RE: The Springs Of Ballentine

*40 Rawls Club Road
Fuquay-Varina, NC
Mr. Taylor,*

The following is a response letter for the above referenced projects review comments of May 09, 2023.

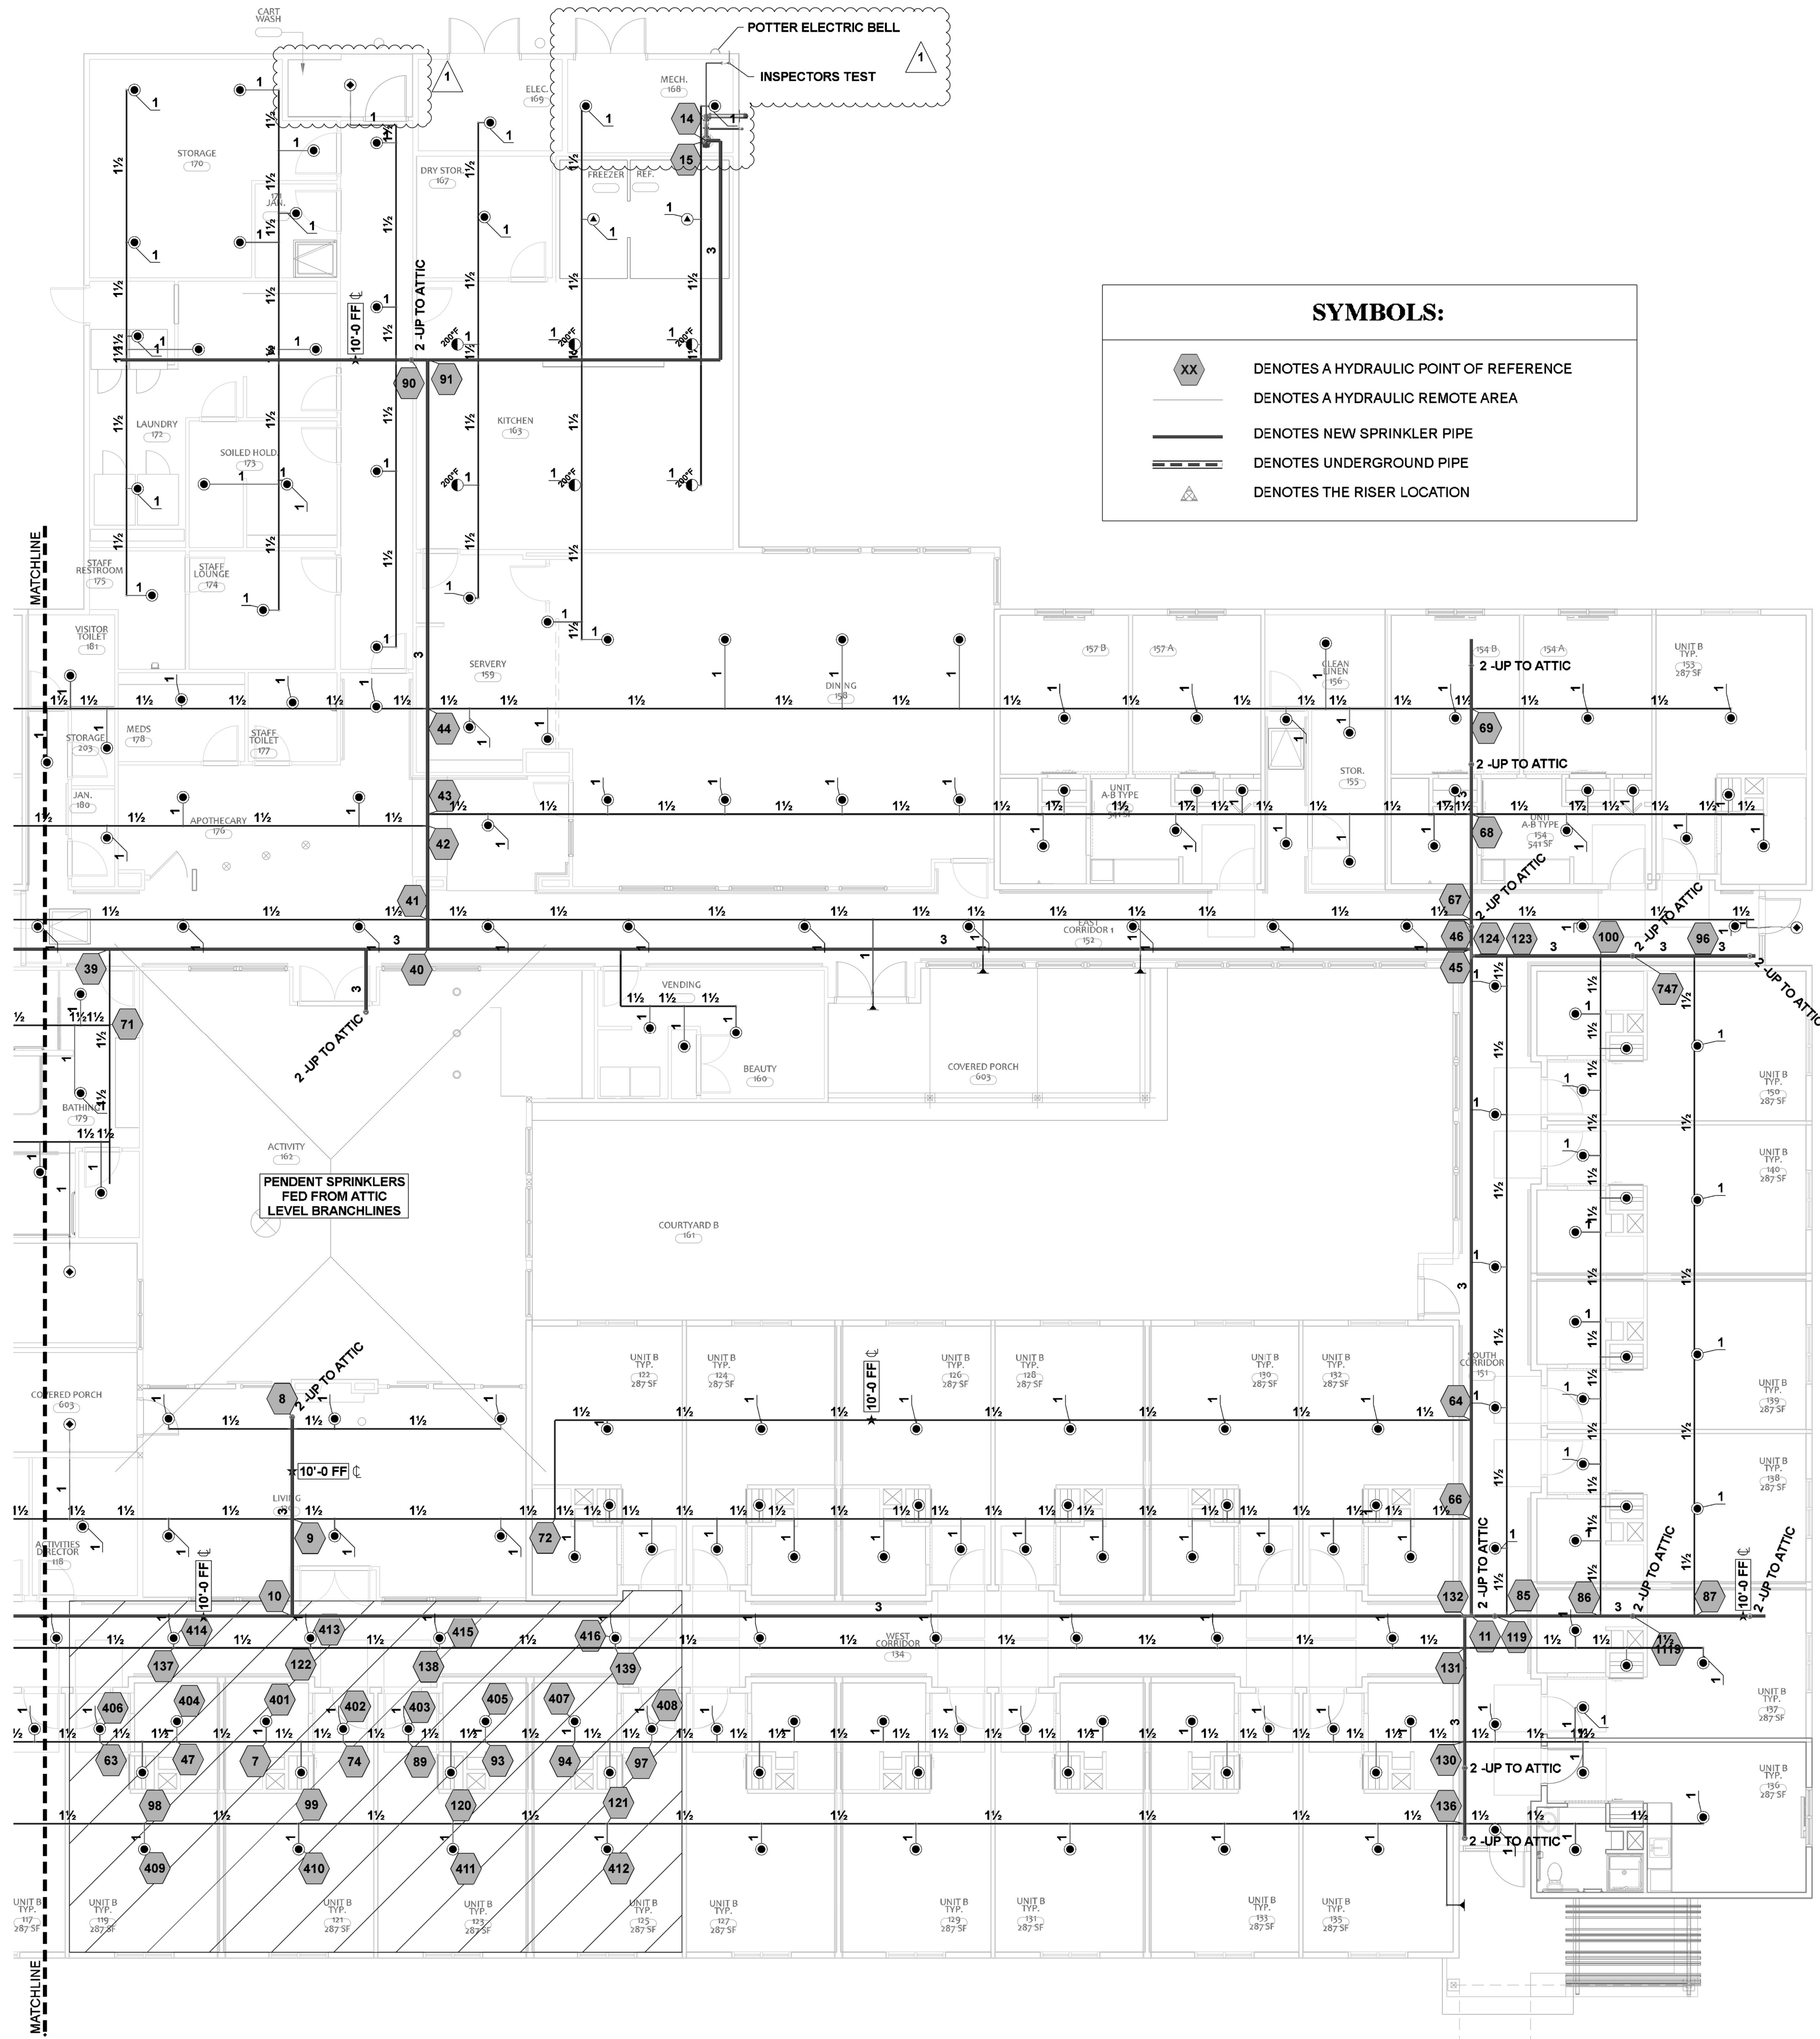
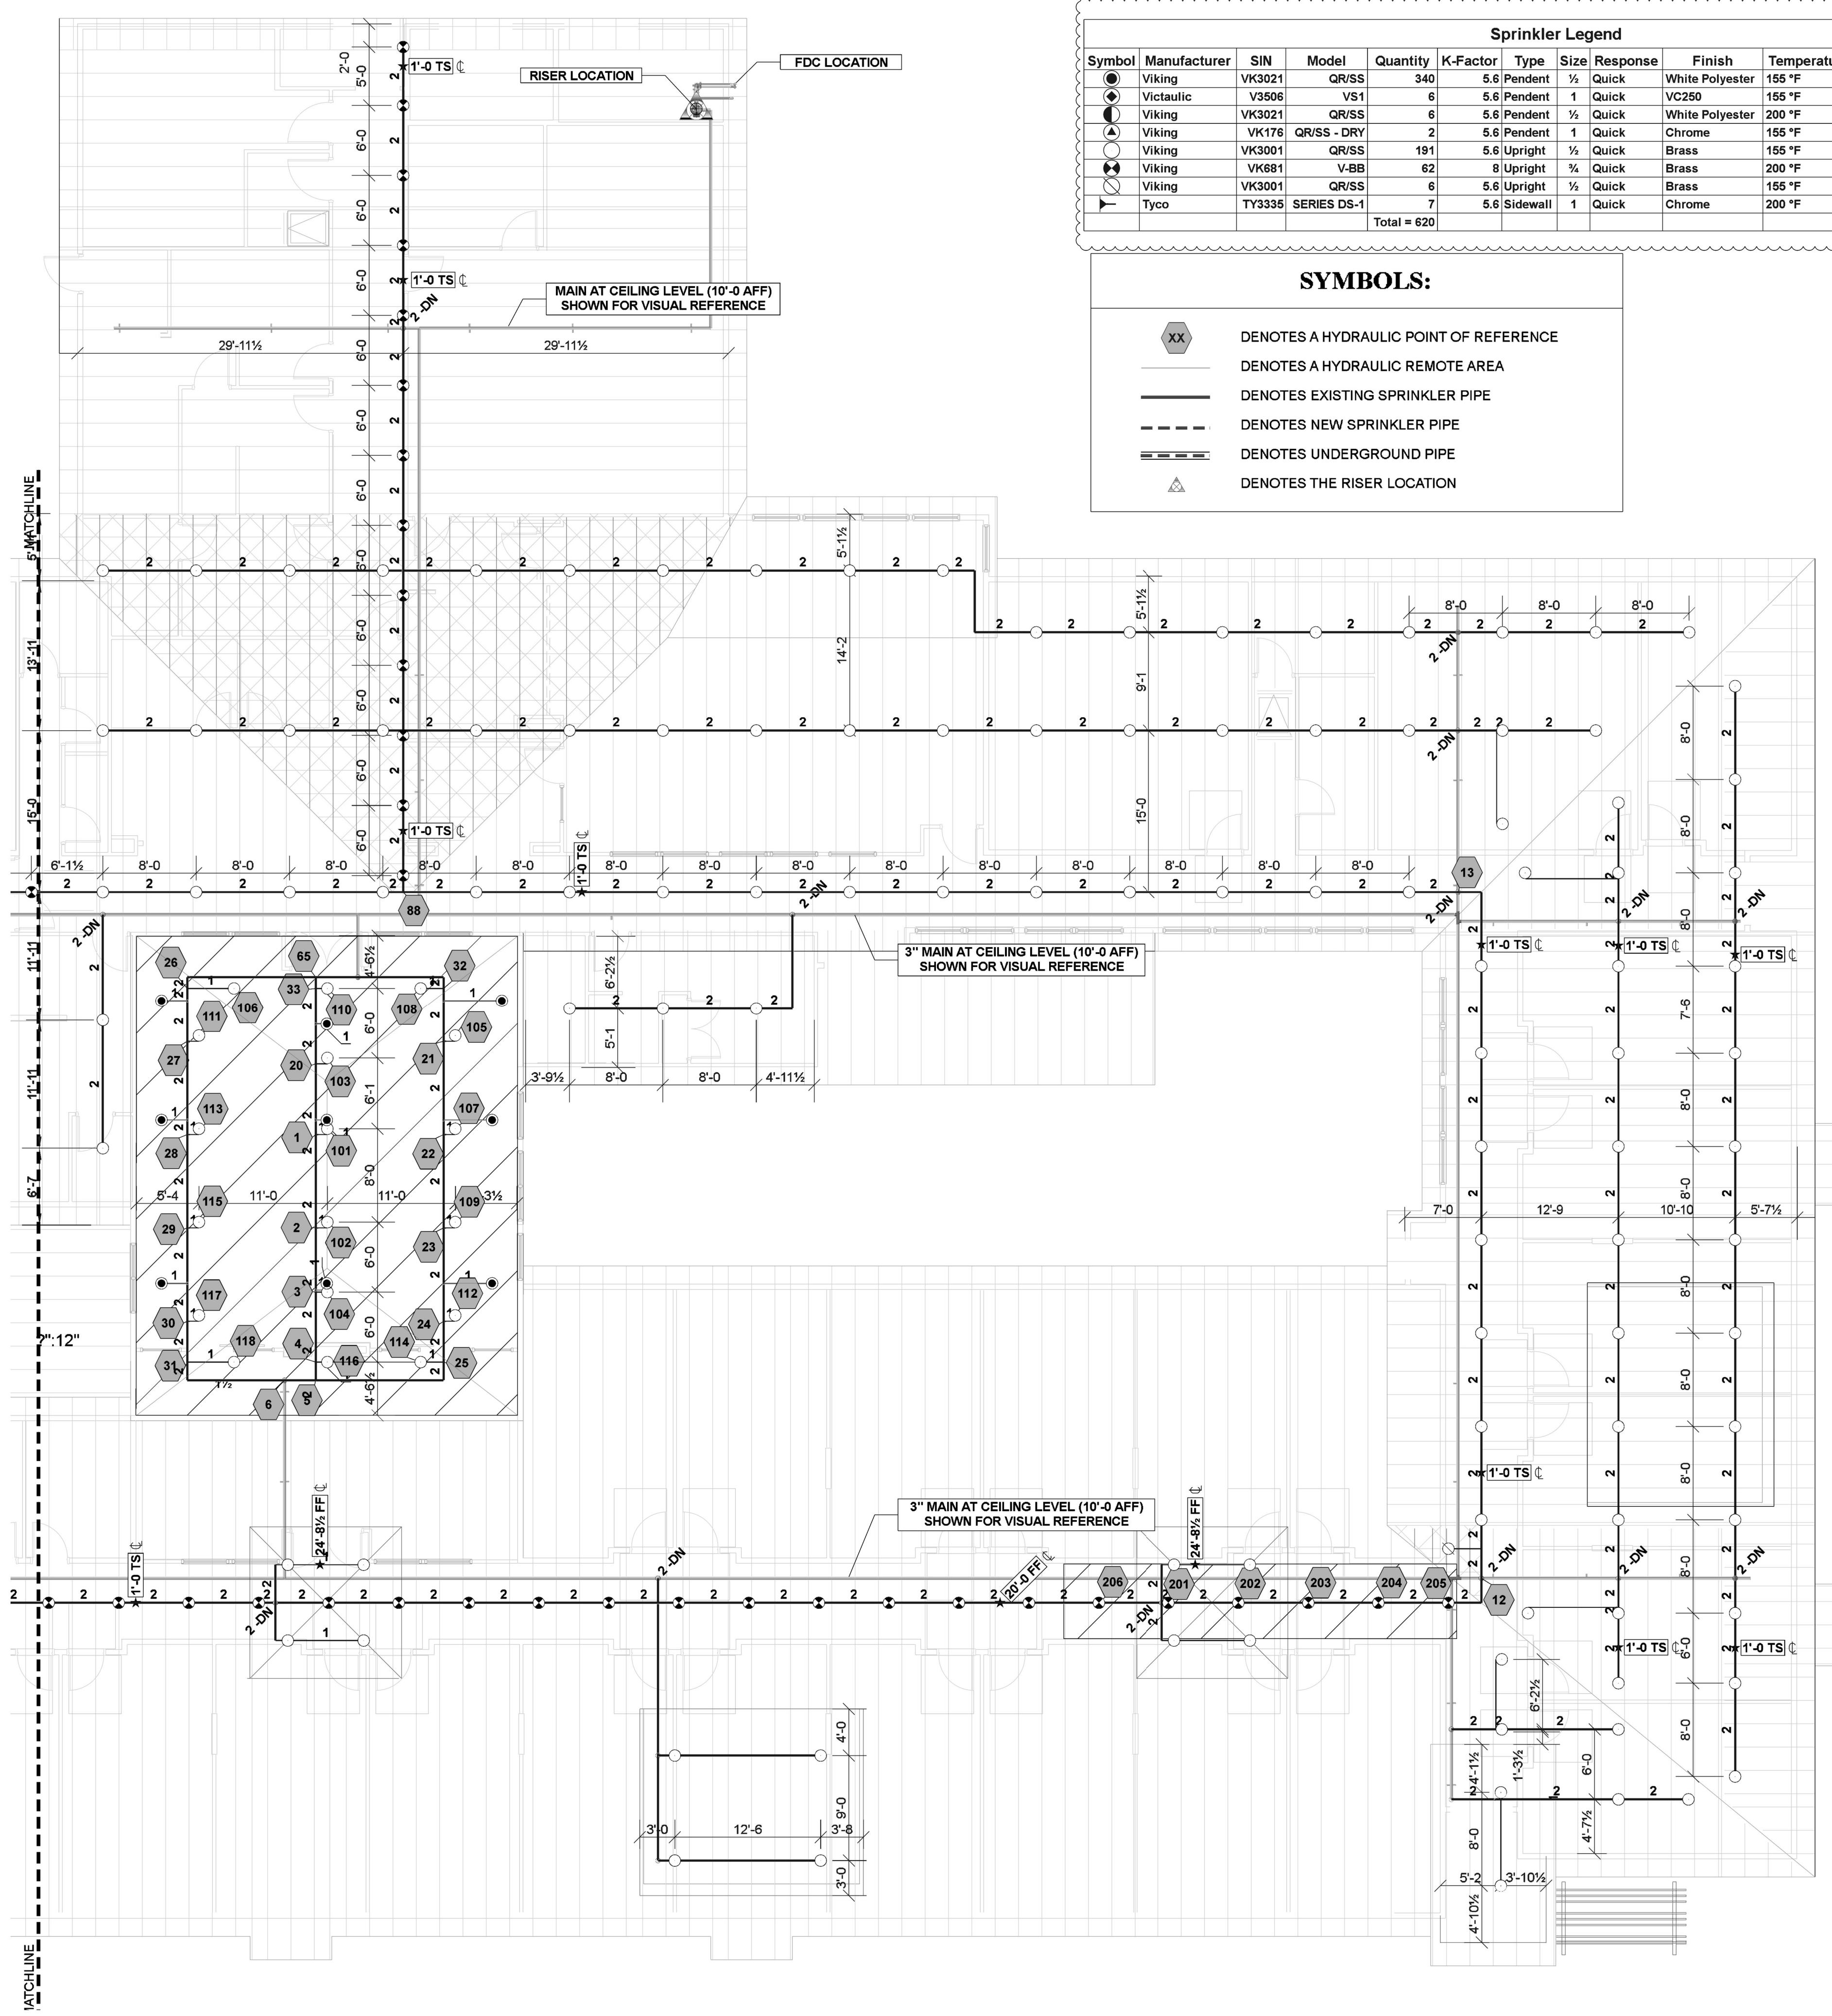
Comment 2: Provide full height cross section, or schematic diagram, including structural member information per NFPA 13, Chapter, Section 23.1.3 #4.
Response 2: Full height cross section now included on page FP-2.

Comment 5: Provide total area protected by each system on each floor per NFPA 13, Chapter 23, Section 23.1.3 #14.
Response 5: Total area protected by Sprinkler System is now noted under the "Sprinkler Design Data" section on FP-1.

Comment 8. The symbol for heads provided in Activity 162 & Lobby 110 are not listed in the Sprinkler head legend.

Response 8. Sprinkler head legend has been corrected & now reflects VK3021 Semi-Recessed Pendants.
